Planning Application Ref: AL/102/17/RES

Location: Nyton Nursery, Nyton Road, Westergate

Description of works: Planning Application seeking approval for Reserved Matters on a development of 268 Units

Arboricultural Impact Assessment Report/Method Statement & Tree Protection Plan

JSL2869_711-713

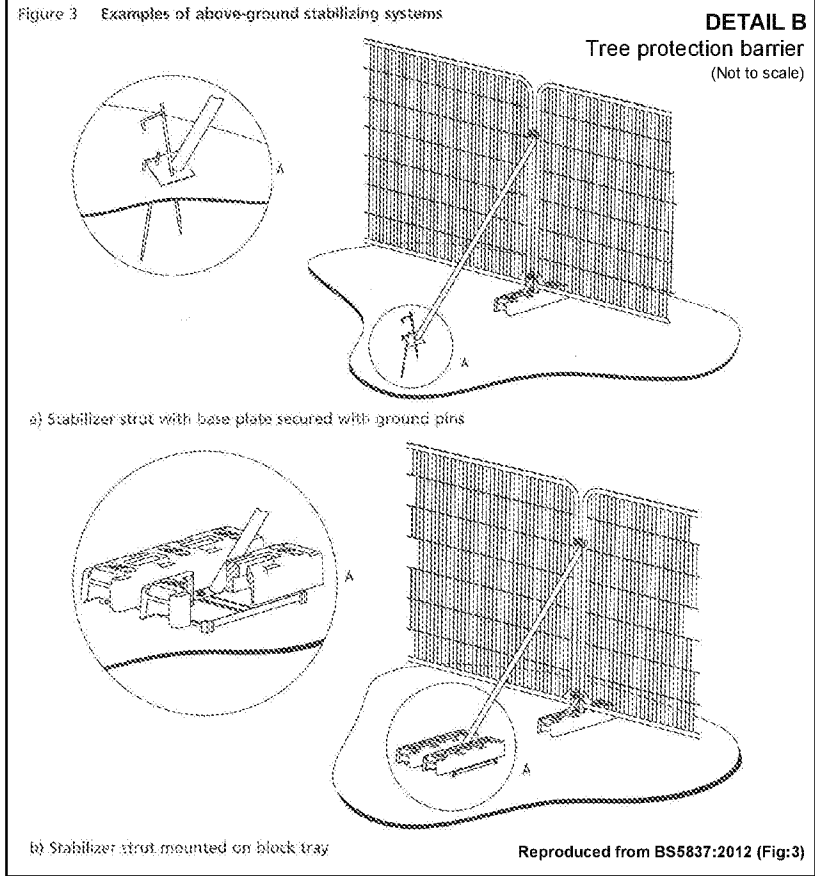
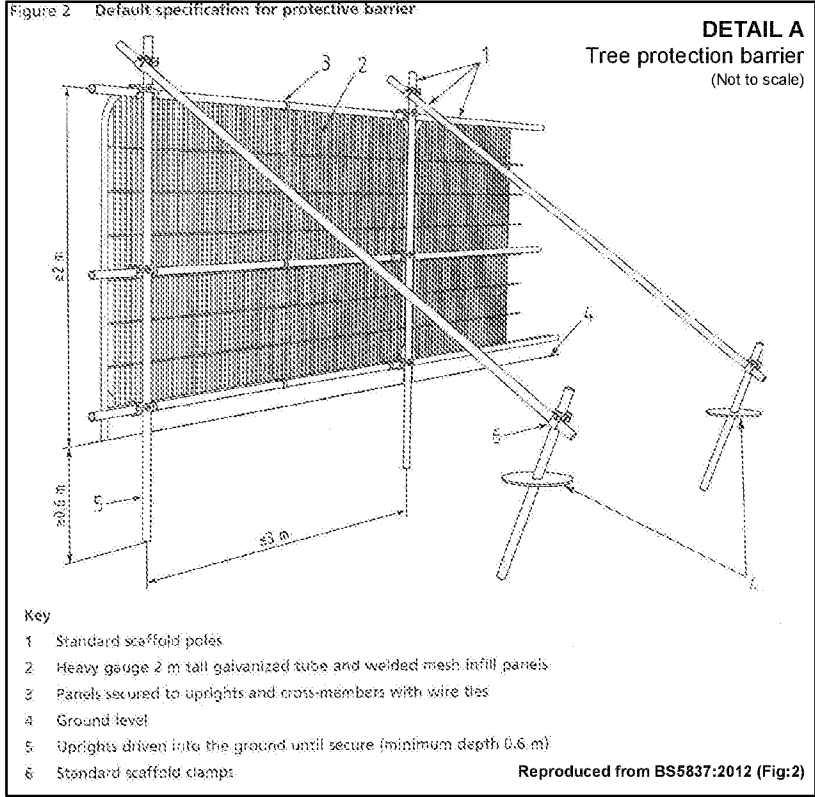
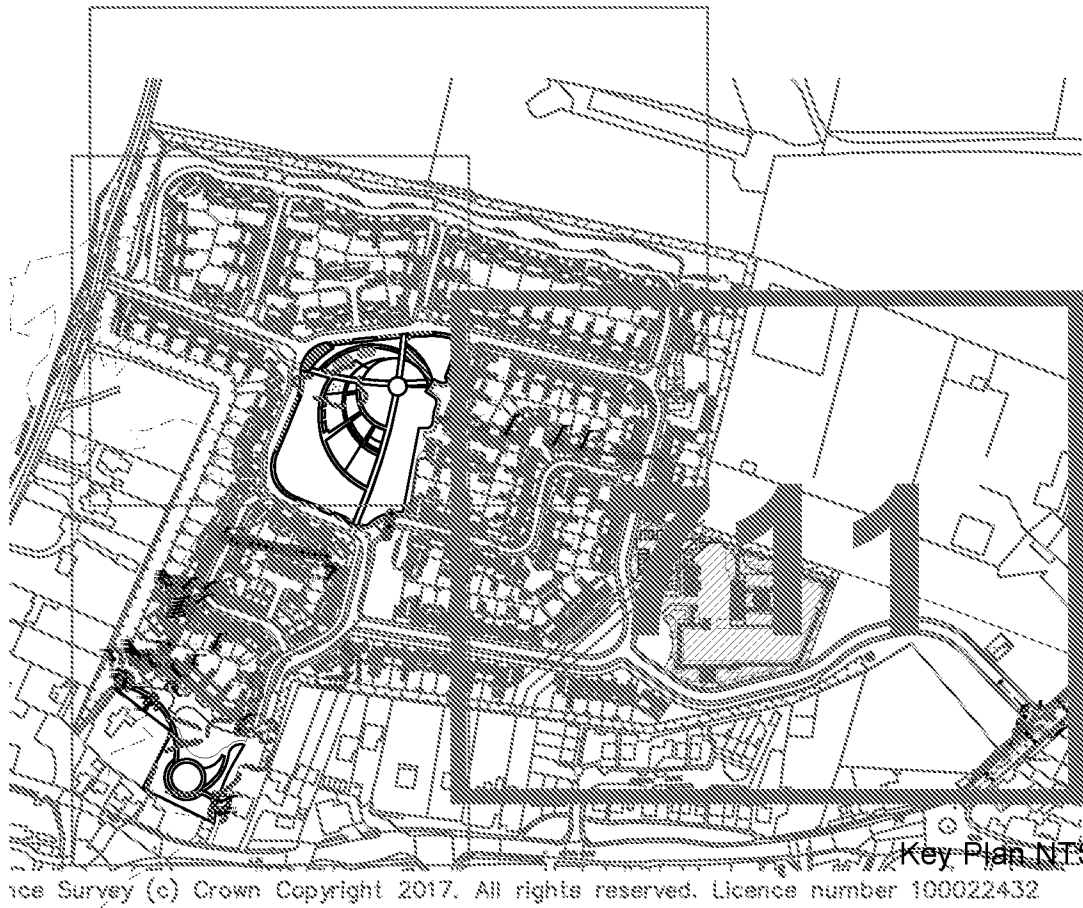
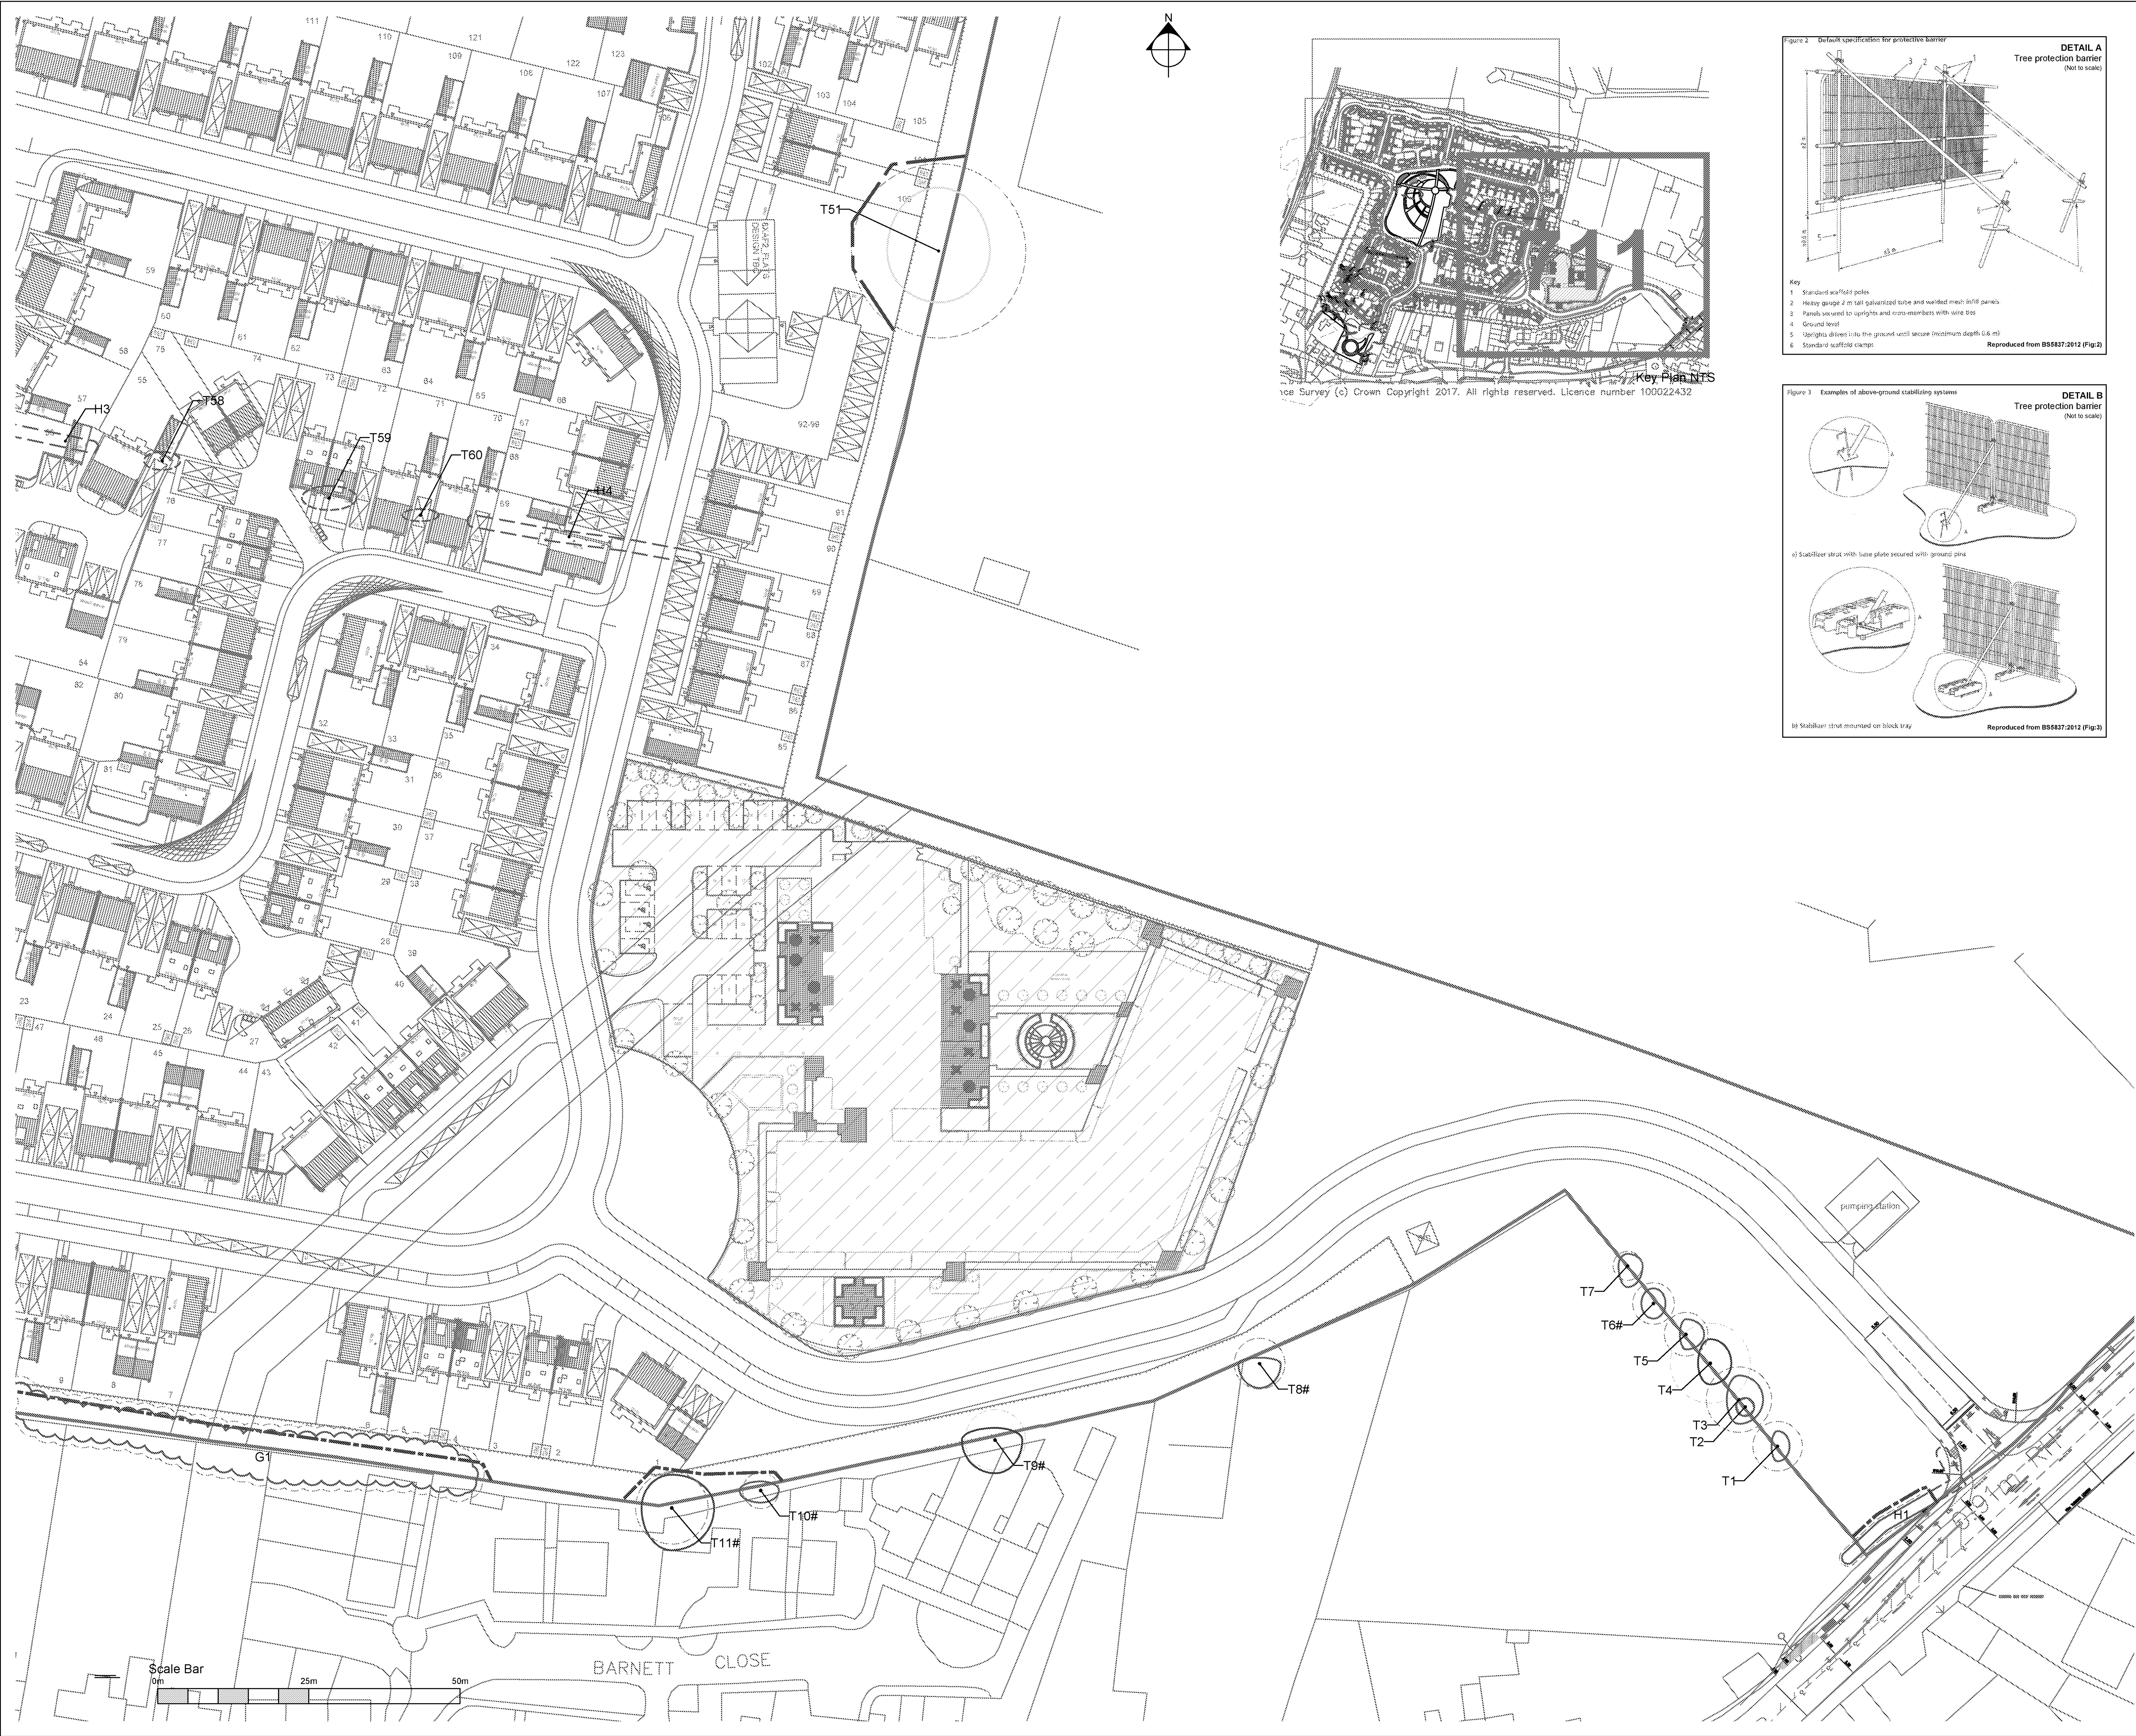
- I raise no issue with the trees which are listed and shown for removal to facilitate this scheme – both in the report and on the **Tree Protection Plan – JSL2869_711-713 Rev B Nov 2017**.

- The specification offered for protective fencing is deemed 'Fit For Purpose' and thus complies with BS5837 – the locations shown for erection and setting out of protective fencing [with the exception of that around T49 & T50] is also acceptable.

- As things stand I would have to register an **OBJECTION** to the current layout on the grounds that it does not fully respect two prime Oak trees T49 & T50.
- I recommend that a TPO is made to protect these two Oak trees along with Oak T51 which is also an A graded tree.

Once they come back in with a layout that is acceptable and fully respects the two Oaks I would withdraw my objection and then wish to see the following Planning Conditions applied:-

(Figure 1; Photograph from Nyton Road; T15 circled)

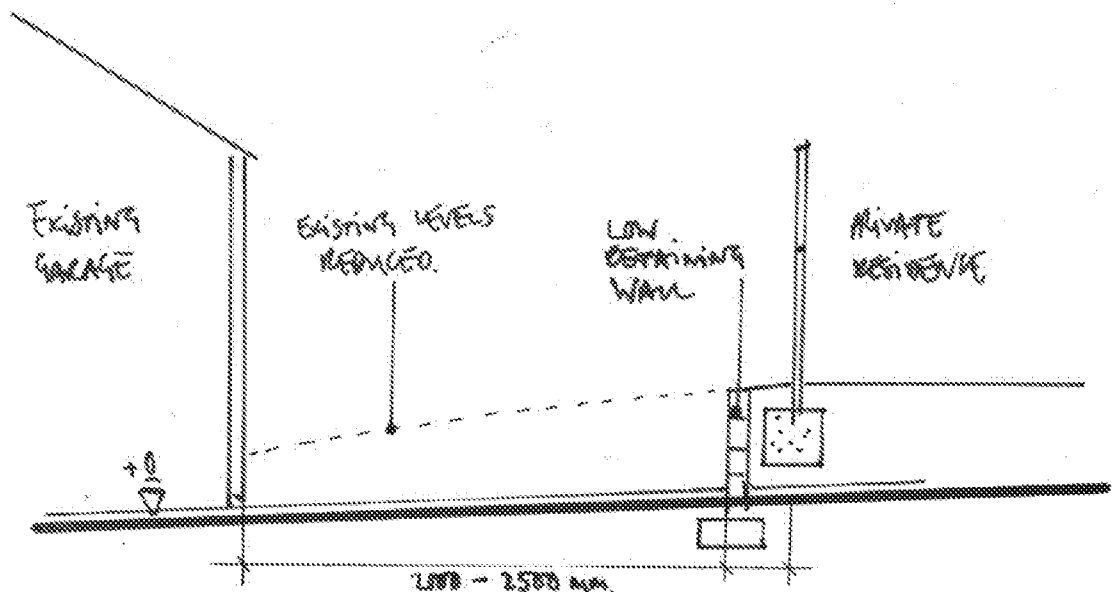
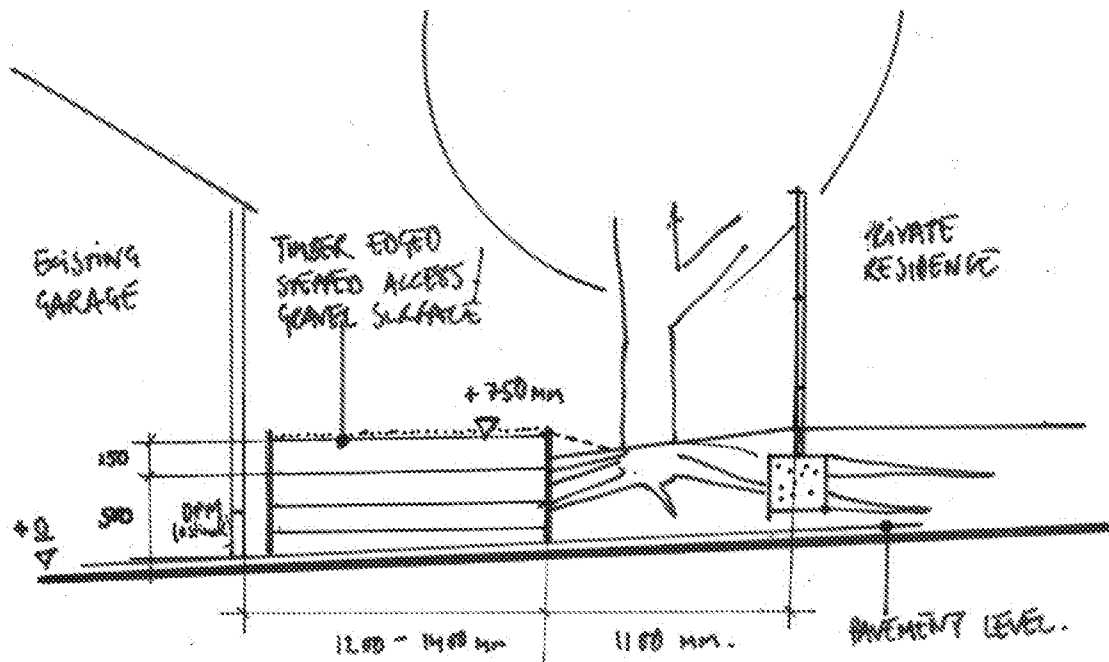
- They also wish to remove the TPO'd Holm Oak (T15 on their survey) in order to facilitate a levels adjustment and to make way for a Cycle Path. I note their technical appraisal of this situation as prepared by David Cox of **RPS Ref JSL2869_772 – 27 November 2017**. I tend to agree with this appraisal in that this is a young tree of limited value which has a lot of growth potential to come and has already caused significant problems with the associated building such that it has been heavily crown lifted [on one side only] to clear the roof of same with some very large diameter cuts made in the process which are open to infection and decay. My primary concern would be that the future growth and expansion of the trunk will displace the supporting walls of the building given that the tree is roughly 750mm higher on soil piled up against the back wall of the building. Add to this the fact that the damp course to this building is at a much lower level and there could also be problems of rising damp to contend with. All in all I would not give this tree much hope of achieving maturity at his location and it would be best in my opinion if they were allowed to remove this tree and plant several semi-mature Holm Oaks were planted in mitigation as part of the open space planting just to the north of this trees location.
